PLANNING - LEVEL III REVIEW (14-526): MMC Congress Street Medical Building (285KSF) (19 procedure rooms, 64 patient rooms, licensed bed count remains 637)
 Institutional Overlay Zone

IOZ - ZONING ANALYSIS

# Phase 1A - Congress St - Inbound 9/8/20-9/16/20

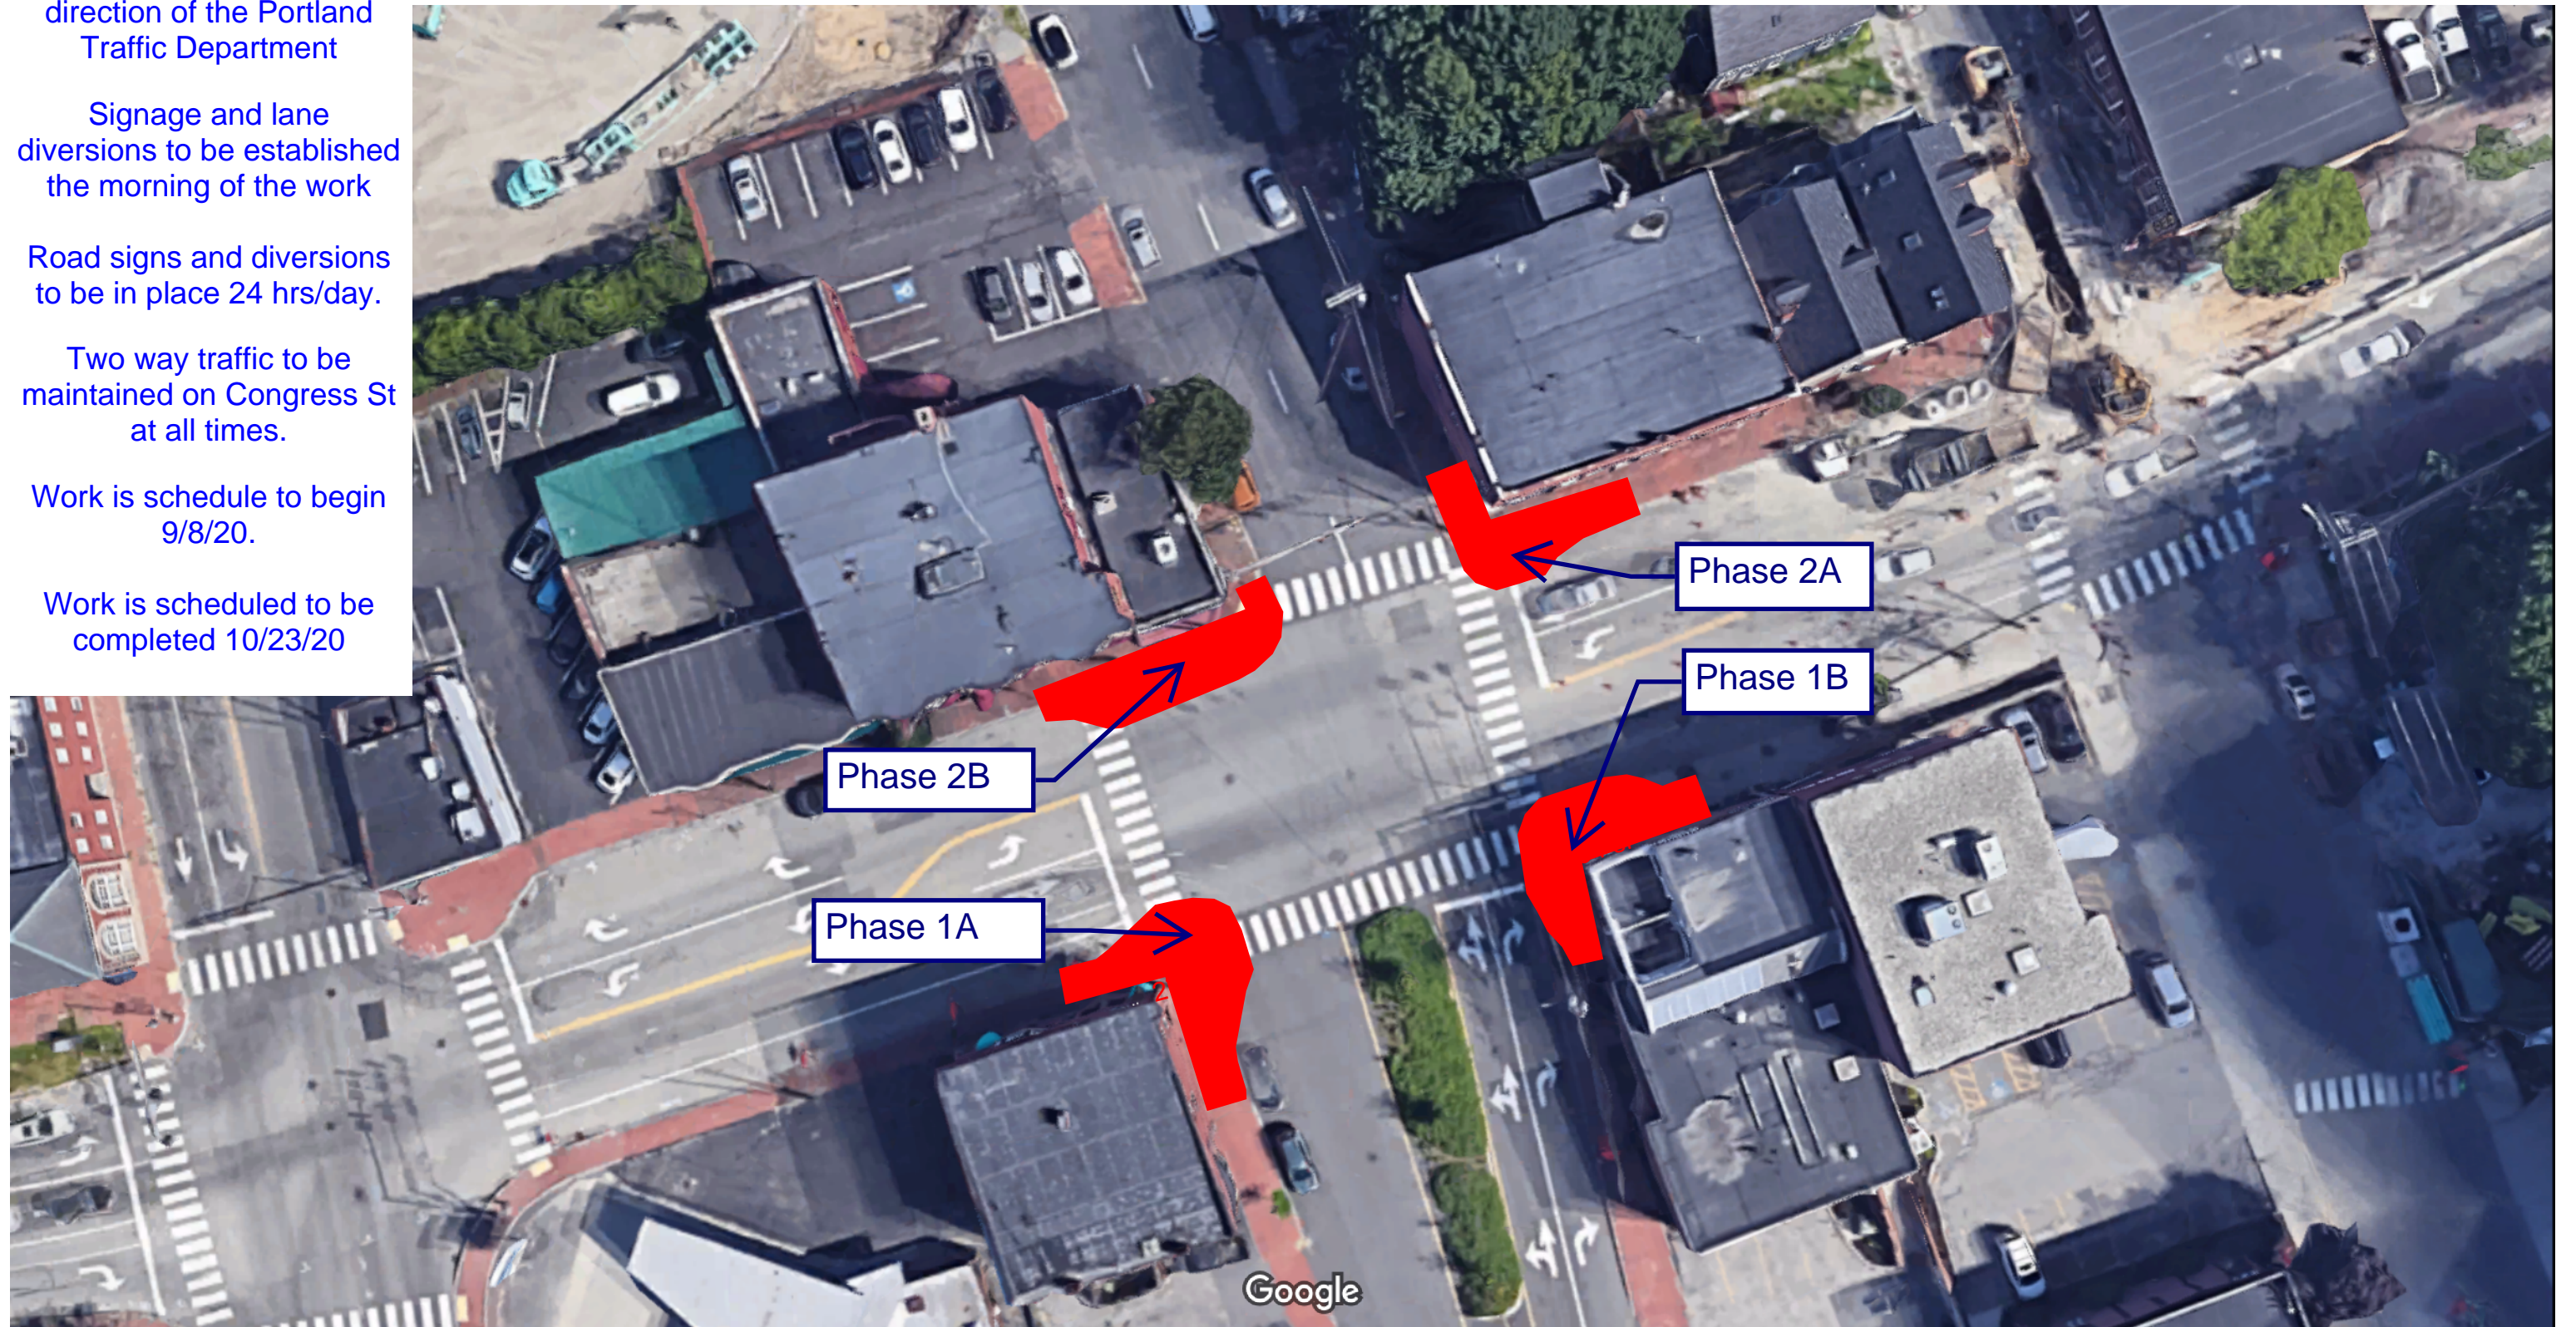
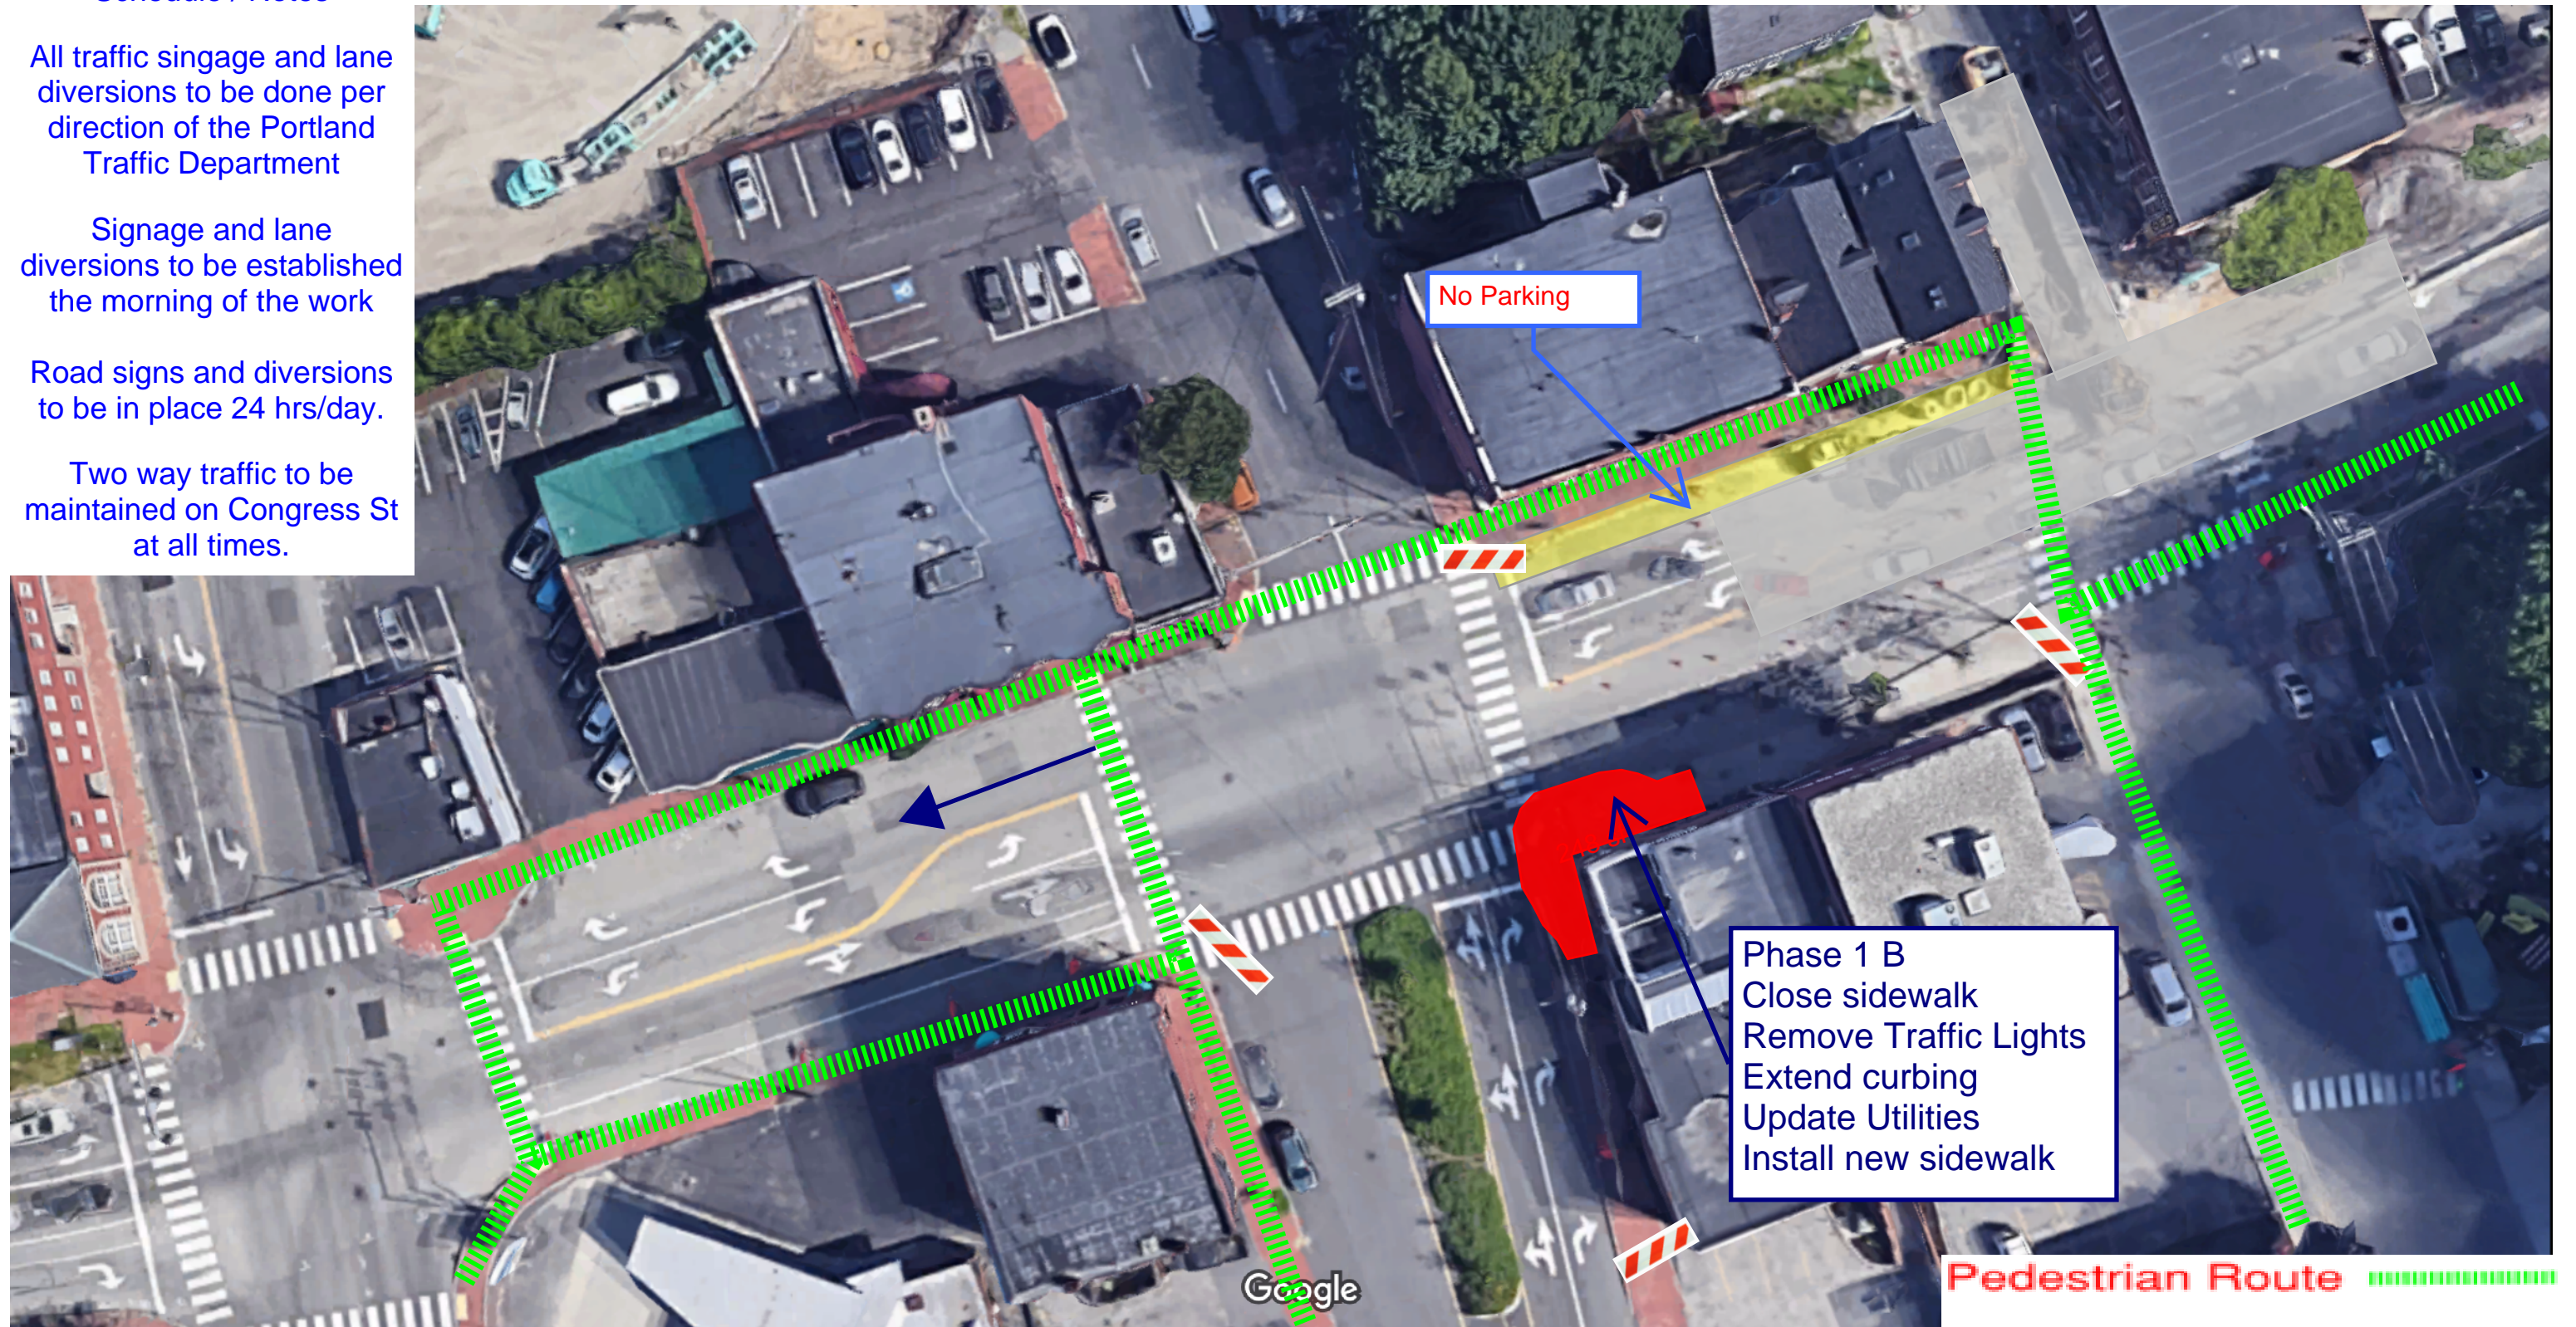
Please provide some discussion on attempts to minimize impacts to pedestrian circulation along the south side of Congress Street. Could sidewalk closure be limited to certain construction/demolition phases?
